INFRASTRUCTURE PLANNING
THE INFRASTRUCTURE PLANNING (EXAMINATIONS PROCEDURE) RULES 2010
THE THANET EXTENSION OFFSHORE WIND FARM ORDER

Deadline 7 submission submitted on behalf of the Port of London Authority and Estuary Services Limited

Unique Reference Number	EN010084
Document Ref.	PLA 30 / ESL 30
Author	Winckworth Sherwood LLP
Date	6 June 2019

Response to the Applicant’s Deadline 6 submissions

Figure 1: Wave height at Goodwin Sands on 30th November 2017¹

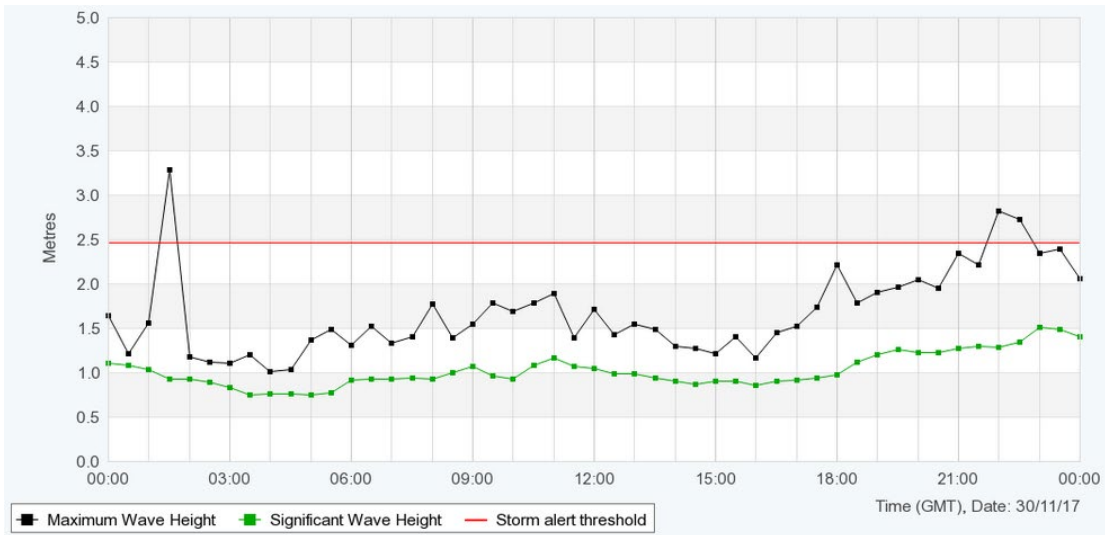
Reference	Response summary/extract	PLA/ESL comments
Para 9	<p><i>“Figure 1 provides reference to wave height data recorded by a buoy at Goodwin Sands managed by the Channel Coastal Observatory (CCO, 2019)*. The data recorded at this location correlates well with the service restrictions experienced by ESL, with storm alert threshold limits exceeded on three separate occasions (a storm alert defined as the level exceed, on average, four times per year).”</i></p>	<p>These conditions are not at the limits of ESL’s operating parameters. The only restriction imposed was ‘no Tongue Deep Water Diamond’ and ESL’s service was only restricted for 11 hours on the day in question.</p>
Para 10	<p><i>“Available historic wind data from website rp5.co.uk (Raspisaniye Pogodi Ltd, 2019) for Manston Airport (approximately 3 miles southwest of Margate) gives an indication of wind strength (average 8.6m/s or 16.7 kts) and direction (from the northwest) in the area on the 30th November.”</i></p>	<p>Even though ESL were operating a restricted service on the 30th November 2017, an average windspeed of 8.6m/s (16.7knts) from the NW is not considered to be in the upper limits of ‘poor MetOcean conditions’. According to figure 2 in the applicant’s submission, there were two recordings of 11m/s (21knts) on the day, again these are not at the higher end of ESL’s parameters.</p> <p>The reason ESL introduced a service restriction of no TDWD operation on that date, was in order to reduce the distance of runs to maintain the boat schedule in conditions that would impact on launch speed. It should be noted that, during the restricted period the crew did not impose a draft and rubbing band restriction. Therefore, indicating ESL were not operating in the upper limits of adverse weather.</p>
